Our Case Number: ABP-318802-24

Re: Proposed development of a resource recovery centre (including waste-to-energy facility)
in Ringaskiddy, County Cork.

OBSERVATION ON SID APPLICATION - Case reference: PA04.318802, Ringaskiddy Co Cork

Proposed development of a resource recovery centre (including waste-to-energy facility)
by Indaver NV t/a Indaver Ireland

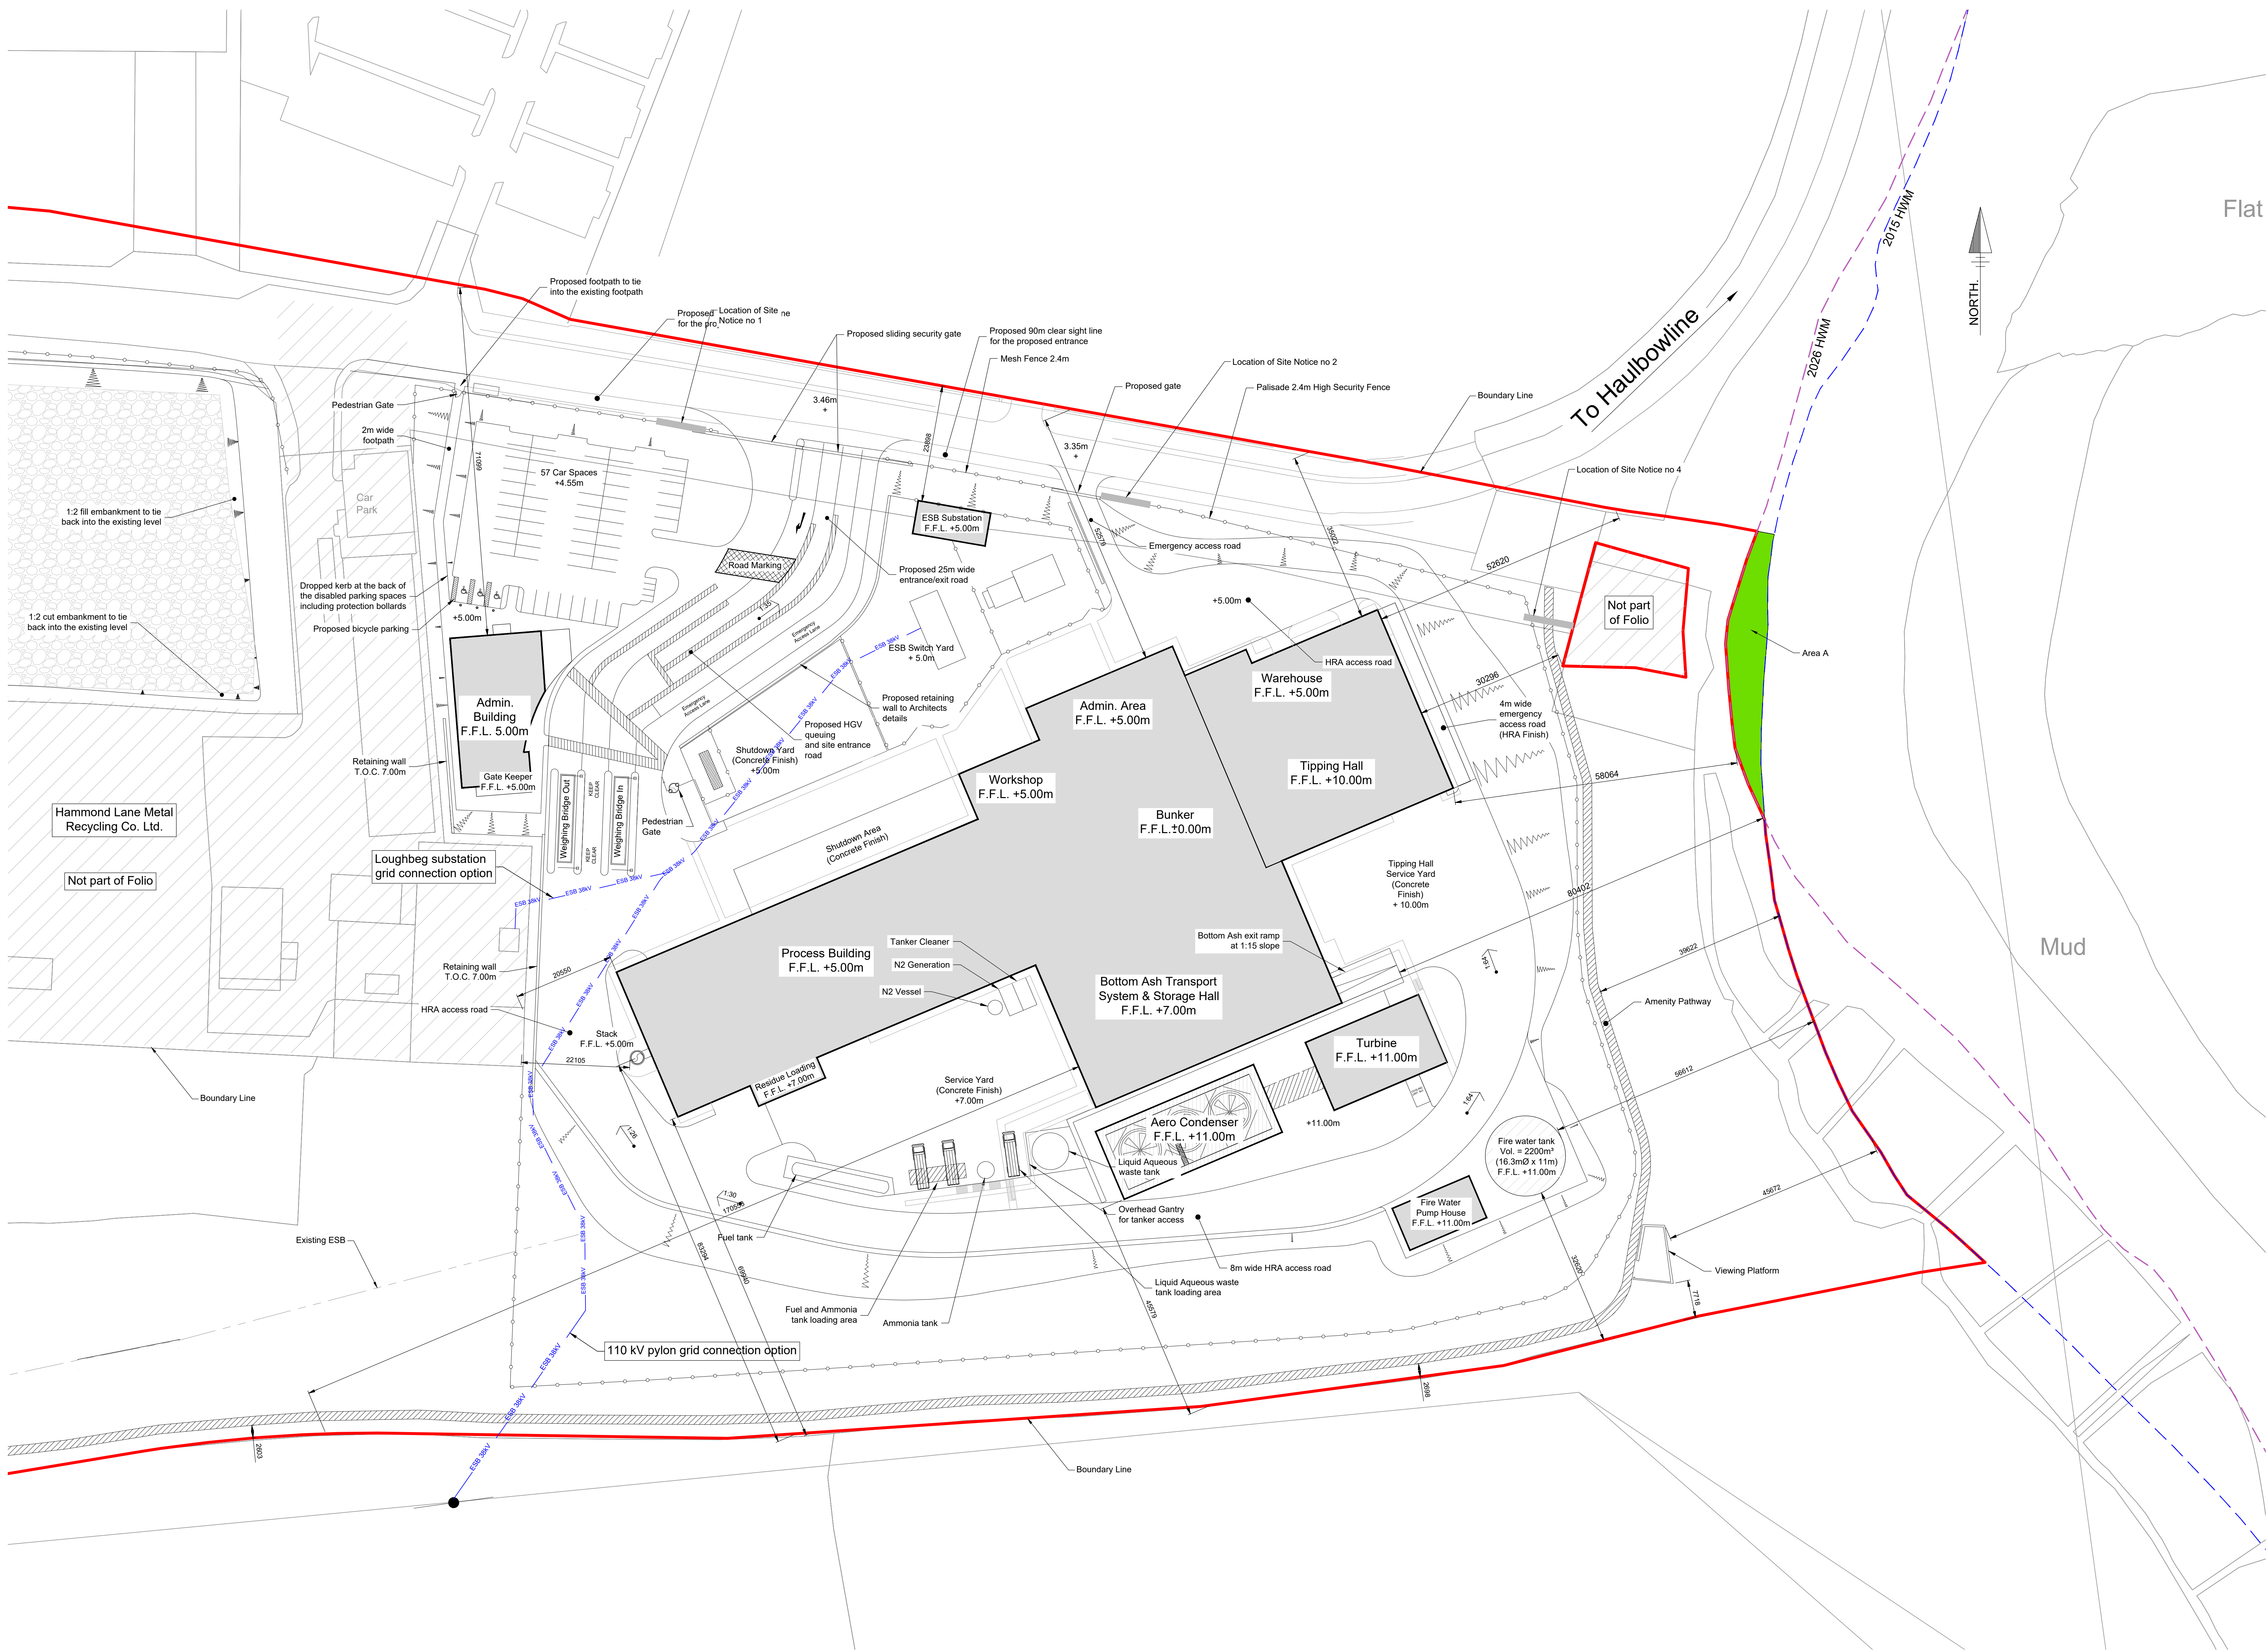
Notwithstanding the information submitted in August 2025, the site is fundamentally too small for the project proposed and continues to reduce in size, with coastal erosion on one side and boundary reduced by M28 on the other. *It is considered that the actual usable area of the site is inadequate in relation to the scale of development proposed. (Derek Daly, 2017).*

Notwithstanding the zoning of the greater Ringaskiddy area as industrial, the Indaver site area where the incinerator build is proposed (RY-I-09) is zoned as *suitable for the extension of the Third Level Educational campus and enterprise related development including marine related education, enterprise, research and development. (RY-I-09, Table 4.1.17: Specific Development Objectives for Ringaskiddy, Cork County Development Plan 2022 - 28)* This is dismissed in the August 2025 information but it is of critical importance that this zoning be upheld as it is directly linked to the investment in the NMCI and MaREI Campus areas and the potential for future growth of this sector. The proposed incinerator is therefore in direct contravention of the County Development Plan and contrary to the specified objectives for the immediate area.
